Subject: Y/70/20/OUT - Issues with drawings

I have had a couple of concerns raised by local residents as to possible inaccuracies with the submitted plans and I invite you to consider these and if necessary, provide corrected plans. The concerns are summarised below:

FIGURE 2
Proposed new access

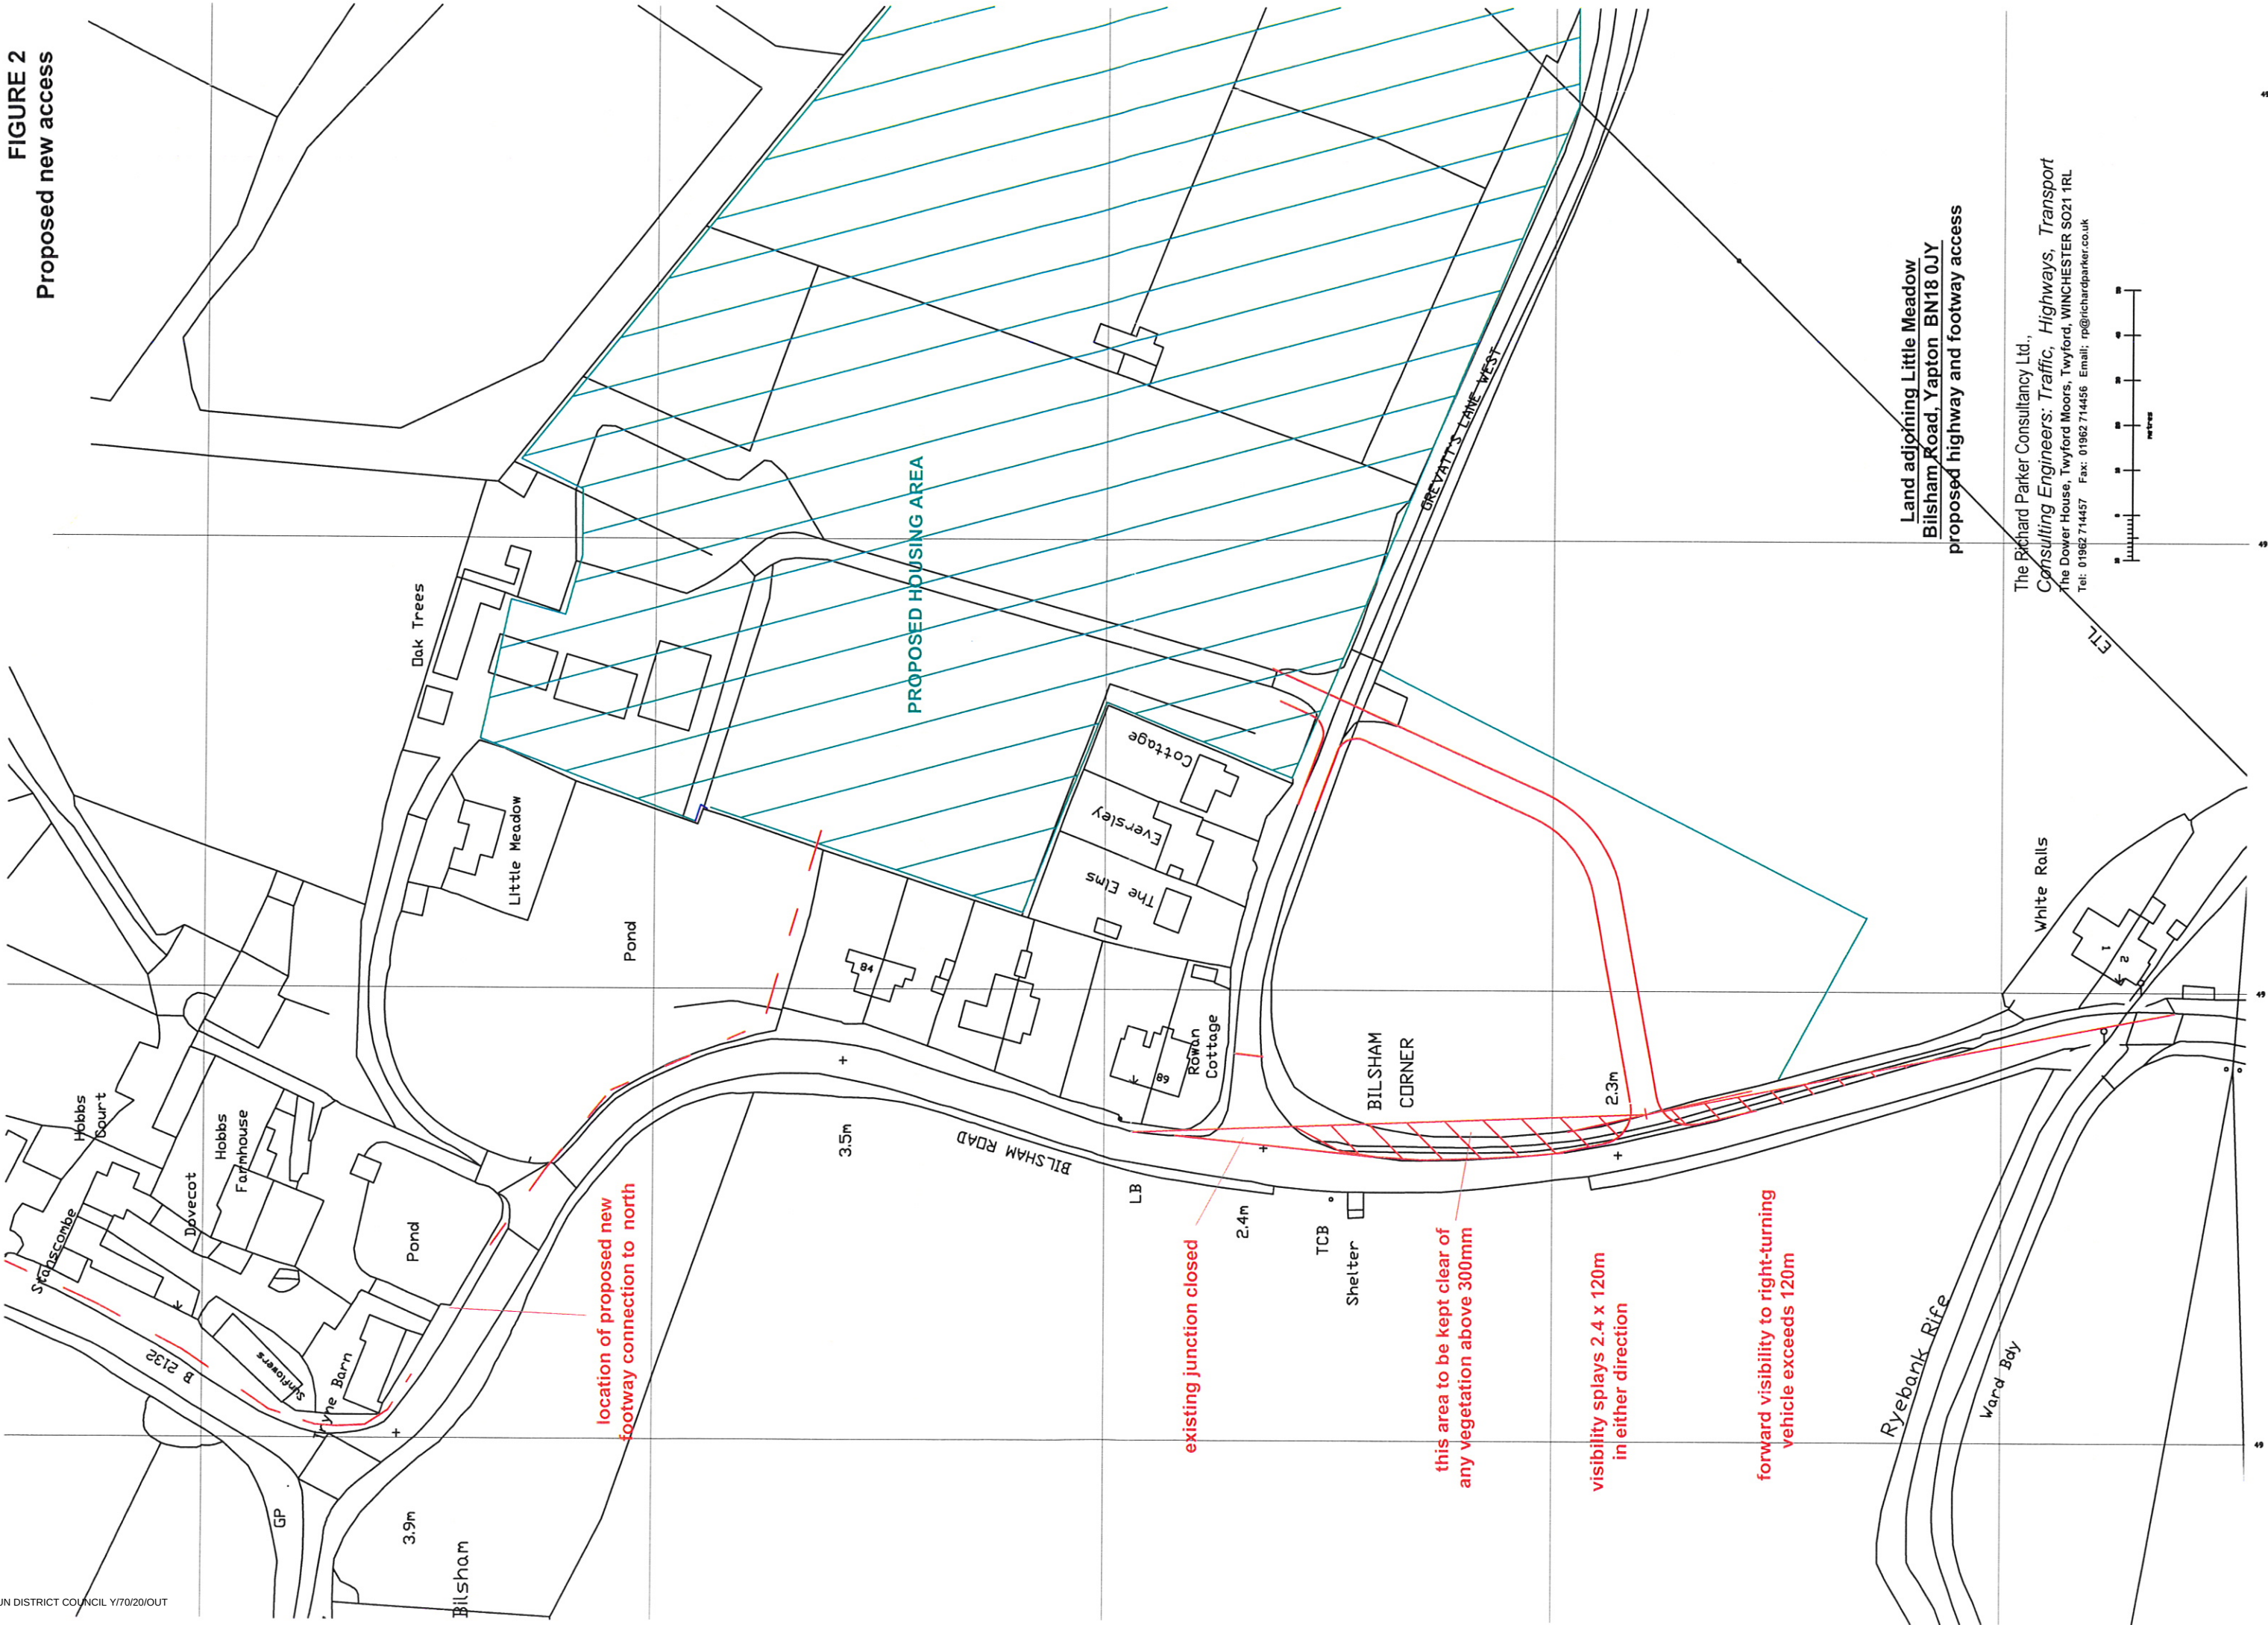
- The buildings at Hobbs Court are not shown or labelled (named) accurately including the Potting Barn (no. 5), The Granary (labelled as Stancomb) and the large car port building on the W side of Hobbs Court;
- The plan showing the footpath does not take account of on road conditions for example dropped kerbs/site entrances such as at The Potting Barn; and
- Apparently, there are other buildings including temporary structures within the industrial site which are not included.

I note re points 1 and 2 that this is only apparent on the access plan and the adopted highway plan (with some of the issues only apparent on 1 of these). I do think that the other plans give sufficiently accurate information to be able to identify any impacts on immediately surrounding properties so it is up to you whether you make any changes, however I had already advised certain residents that I would raise this with you.
